Re: Windermere Final Plat (SF-21-026)

MDT-SF21026-R4-CDs.pdf Markup Summary

**RD03**

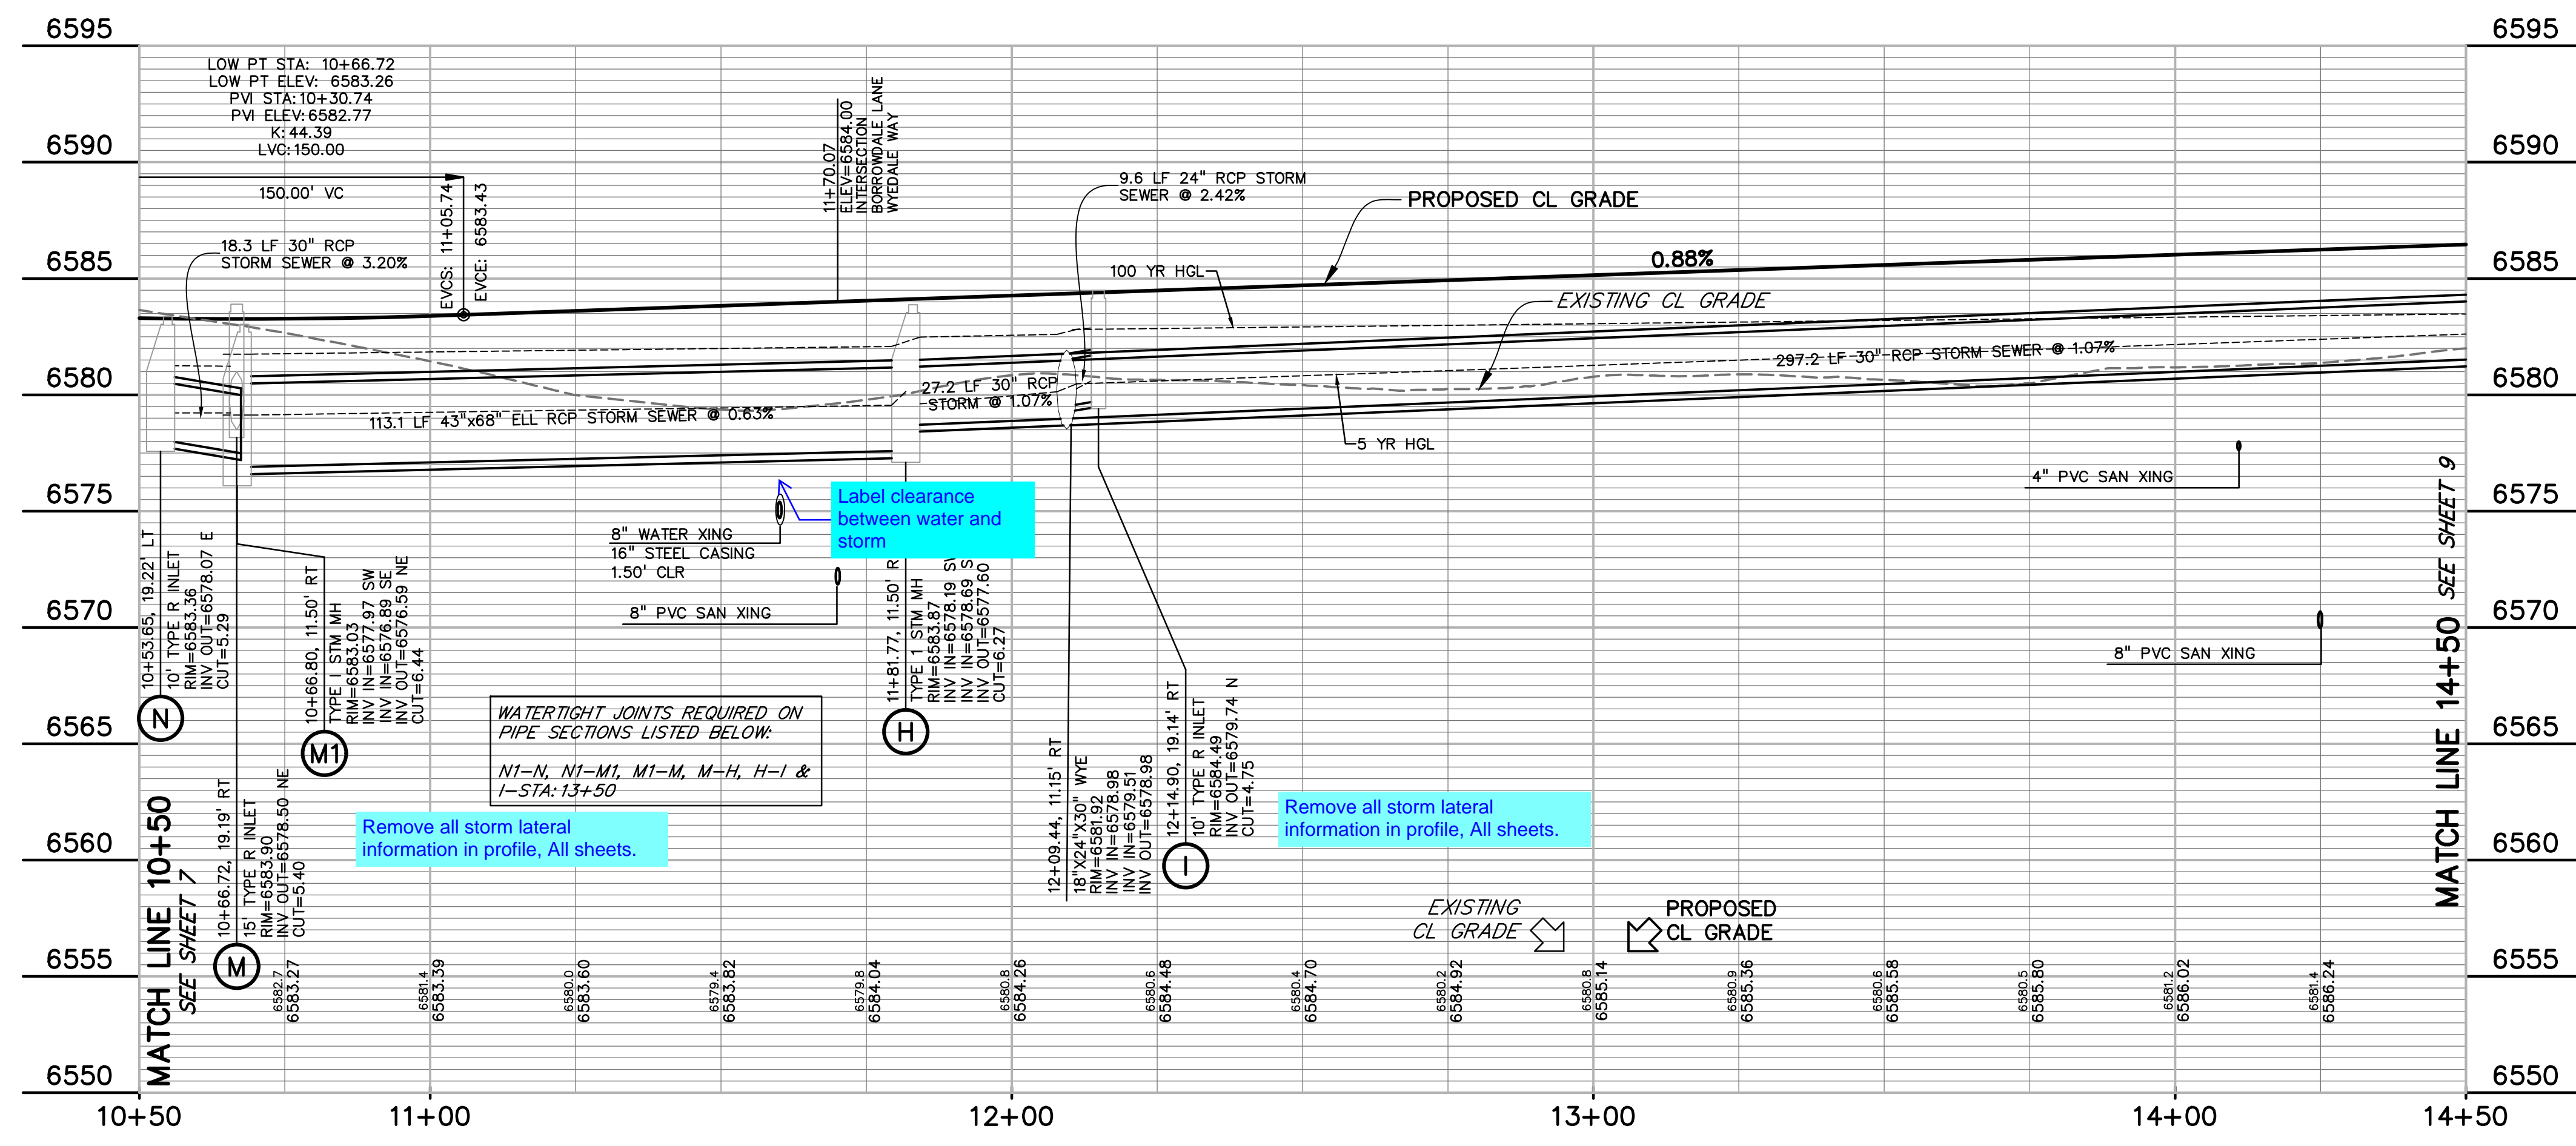
Storm laterals should be separate profiles - All sheets.

Remove all storm lateral information in profile, All sheets.

Label clearance between water and storm

Storm laterals are shown on sheet SD01 & SD02

Lateral info removed as requested

Clearance labeled

**RD11**

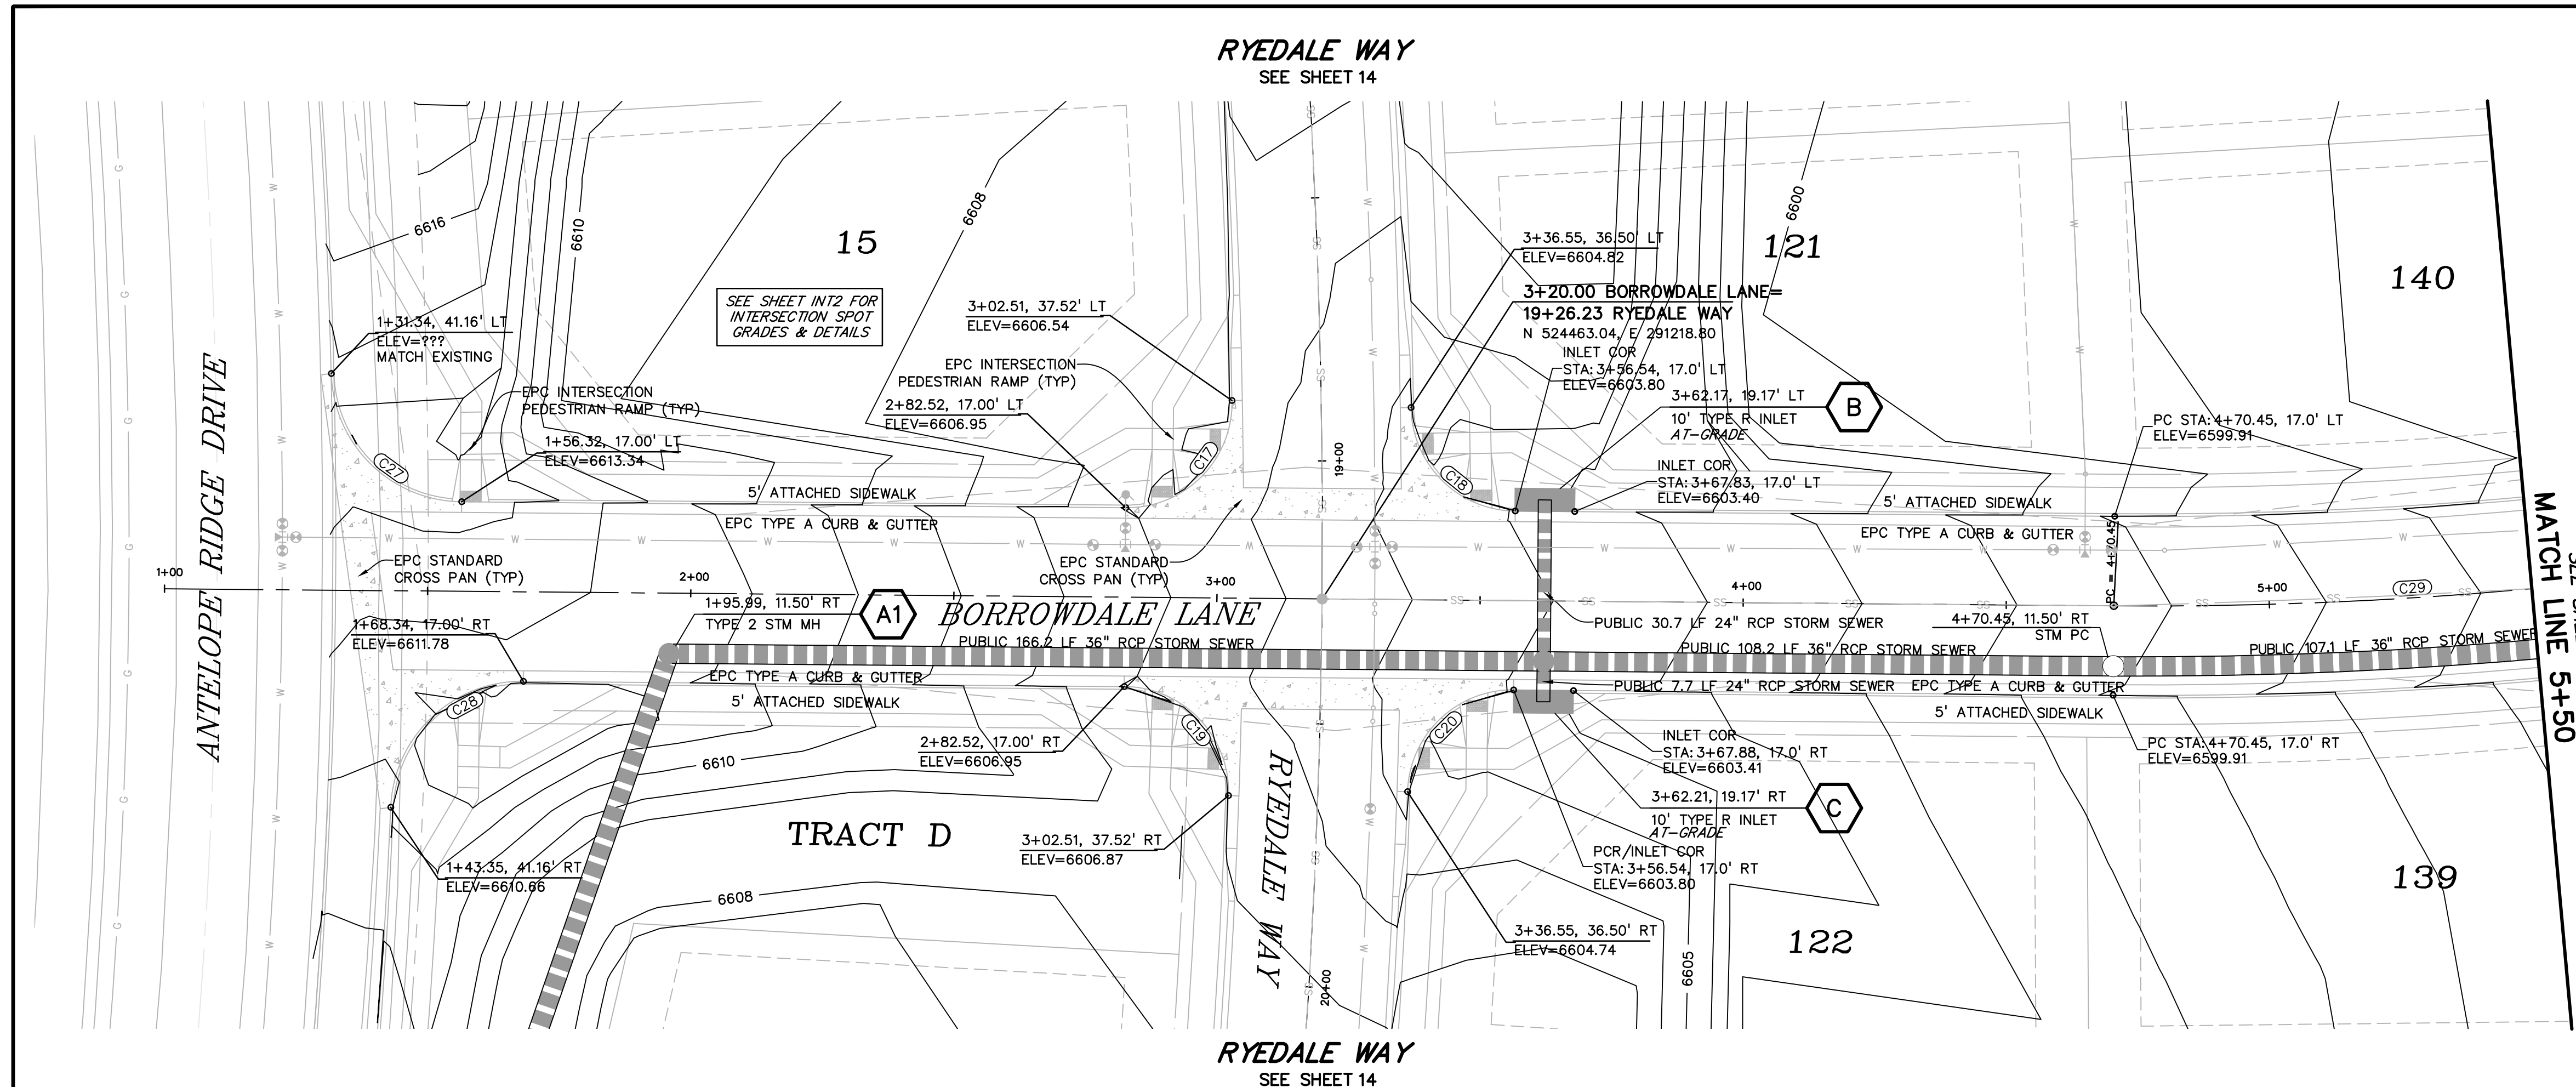
Remove all storm lateral information in profile, All sheets.

Show clearance between water and storm.

Label cover over storm

Lateral info removed as requested

Clearance labeled

Cover labeled

**SD02**

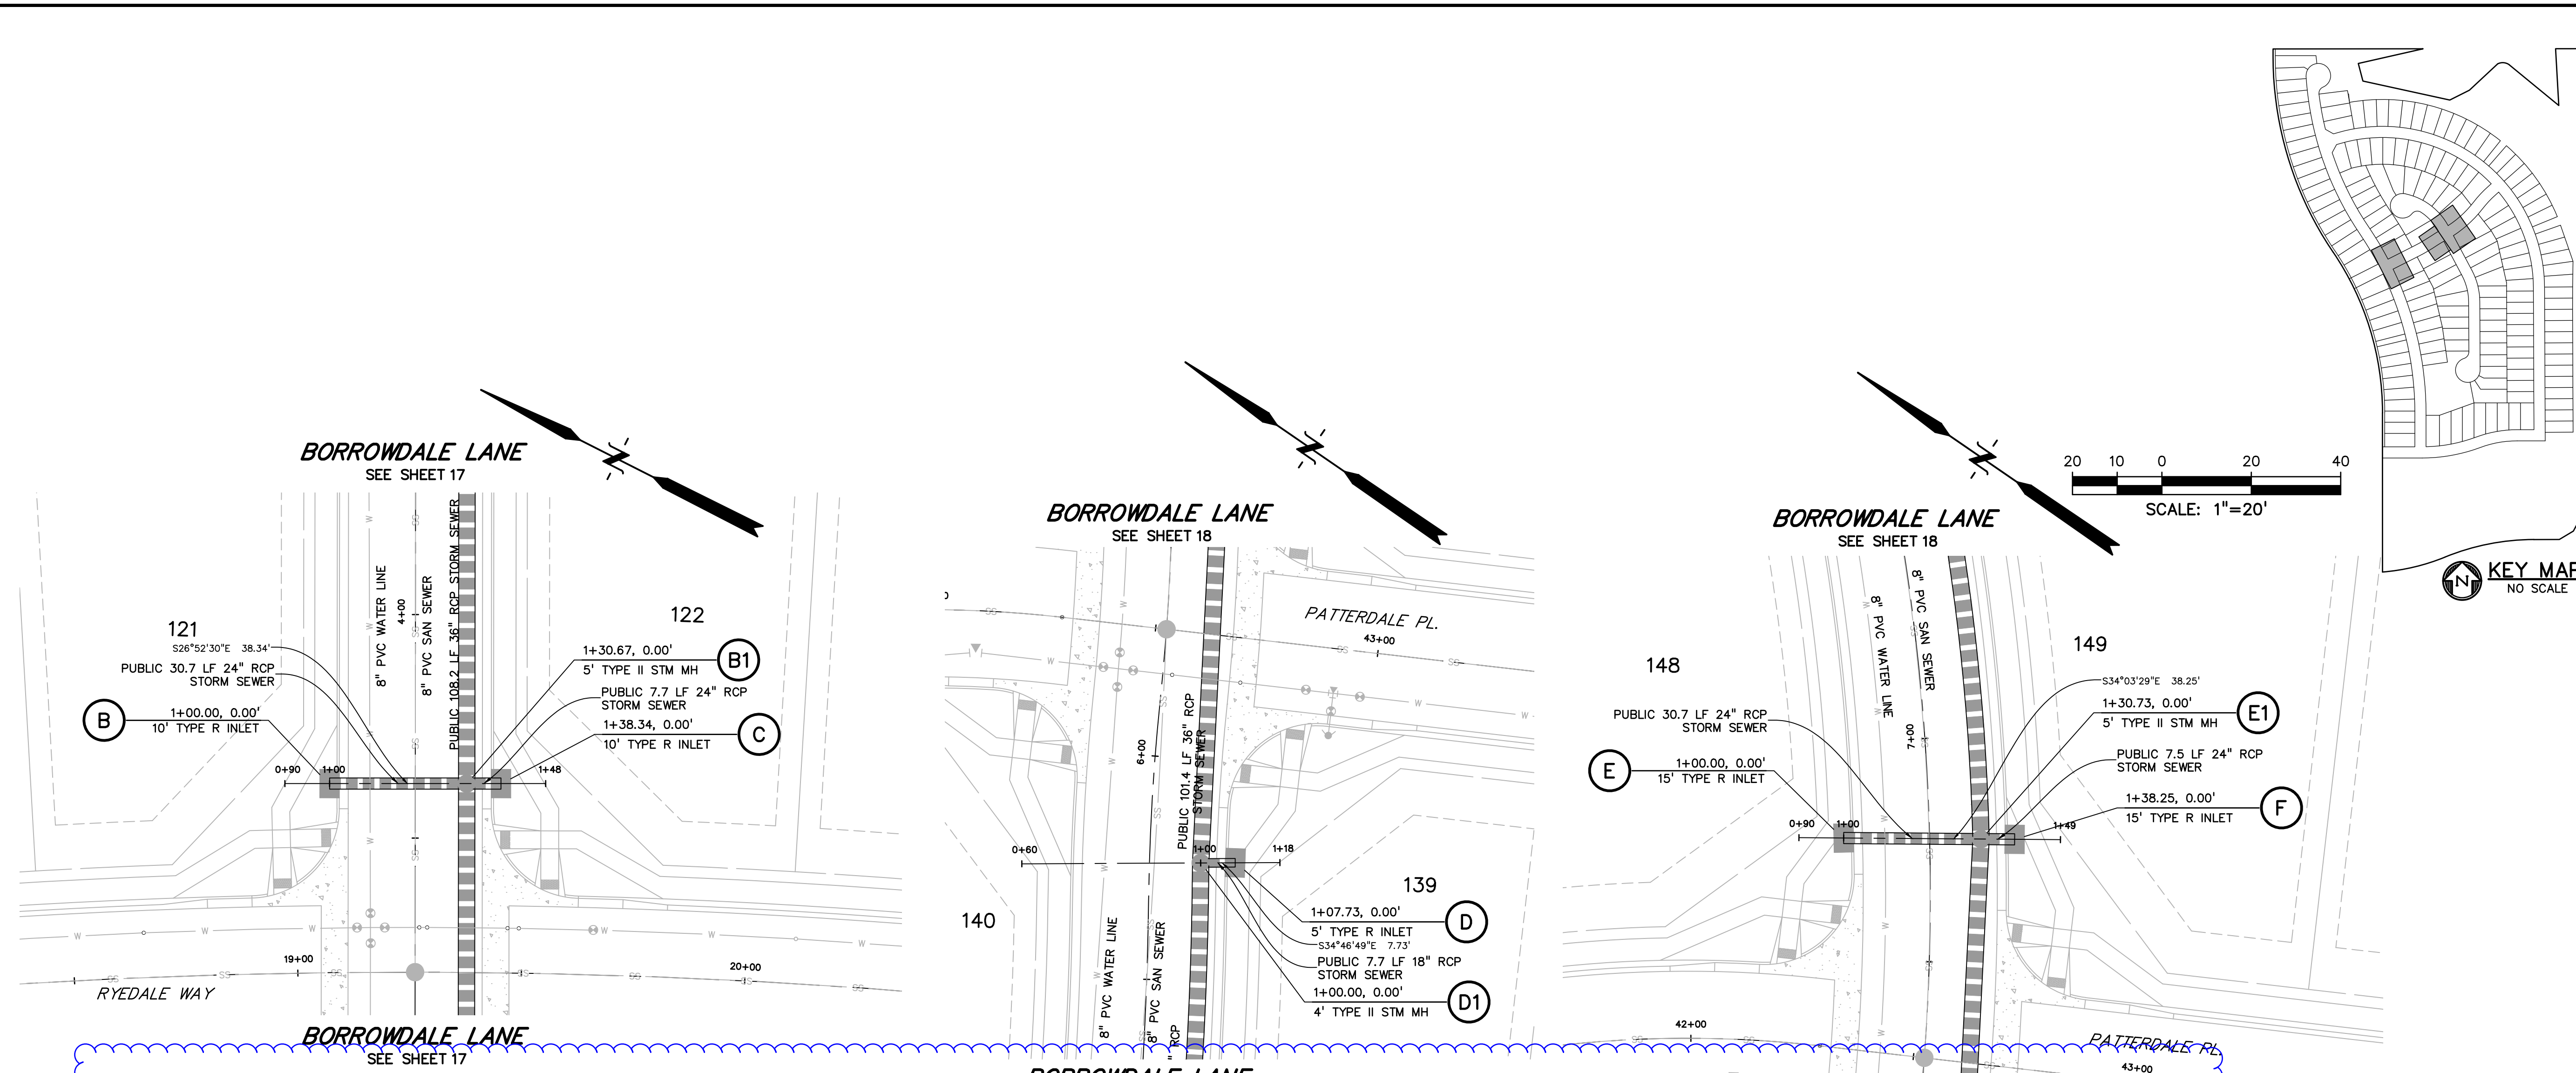
This portion of storm sewer (Pipes 19,12,20, 21 & 13 per UDsewer layout are not part of the output information. Please include in next submittal for review.

They were included in the prior FDR. I've since added sheet numbers, so ref pages 145-148 for 5-yr and 170-174 for 100-yr
